Planning Application No: 3/2025/0959

Proposal: Proposed two storey side extension, single storey rear extension and widening of the existing driveway.

Location: 11 Clitheroe Road Sabden BB7 9HD

Tahira Akhtar BA (Hons)
Technician
Highway Development Control
Highways & Transport
Lancashire County Council

Client Mr and Mrs Skellern		
Project Proposed Works to 11 Clitheroe Road Sabden Clitheroe BB7 9HD		
Drawing Title Existing and Proposed Site Plans		
Scale 1:100 @ A2	Date Dec 2025	Drawn LFR
READ DESIGN LTD		
177 - 03

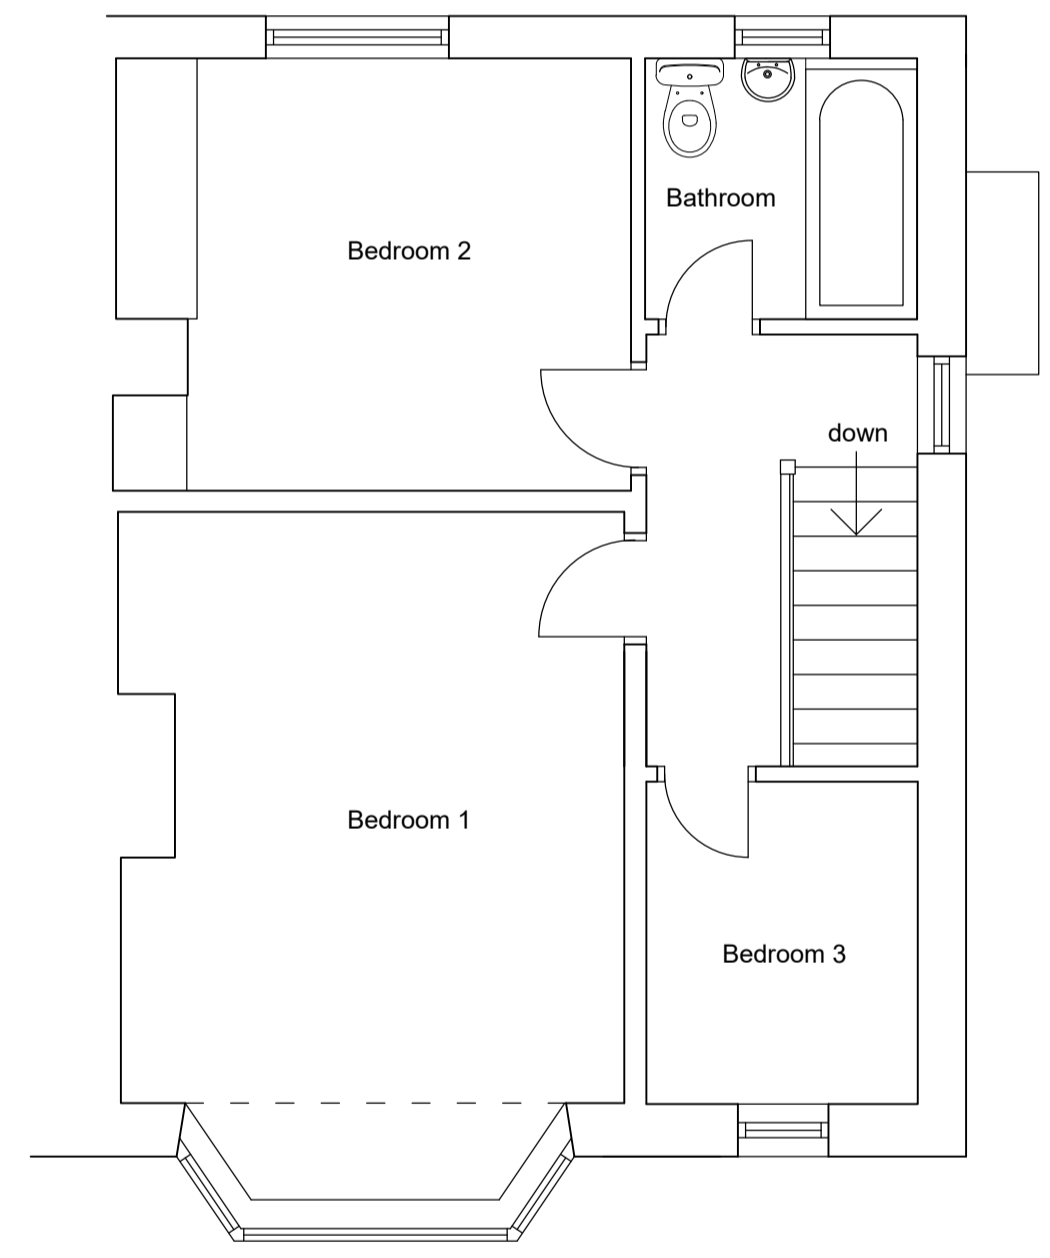
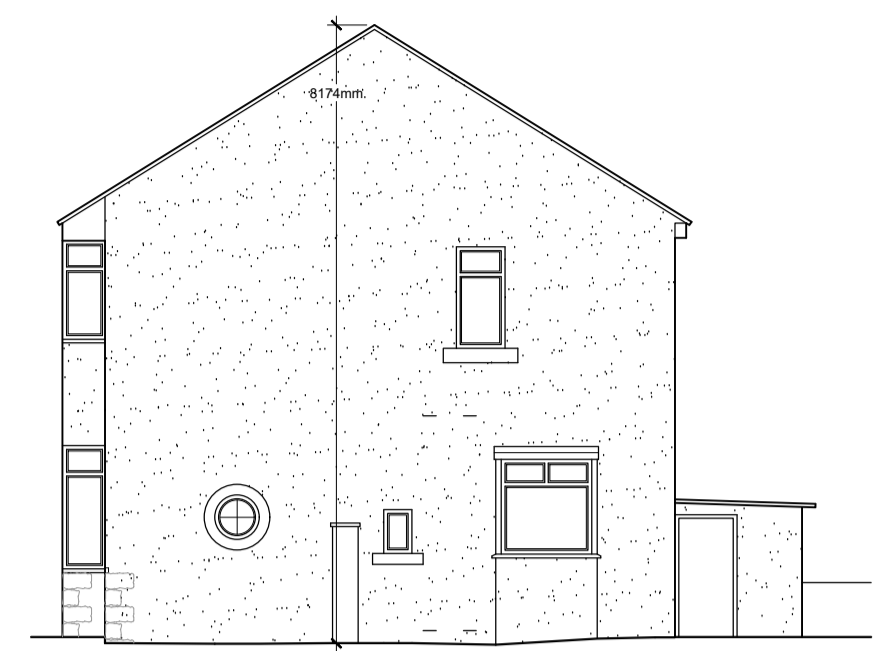
There is no increase in number of bedrooms with this proposal which will remain at 3. Parking standard requirements for a 3 bedroom dwelling is 2 parking spaces and these can be provided on the drive once it has been widened.

Ref. Design, access and Heritage Statement, Ref. 177, Rev A, 14.1.26, and Existing and Proposed Site Plans 177-03 submitted there is no objection to the proposal subject to the following condition and comments being noted.

- The parking areas must be constructed of a bound porous material and created before first occupation up until the lifetime of the dwelling existing in its proposed state. Reason: To ensure that satisfactory parking is provided before the dwelling hereby permitted becomes operative.
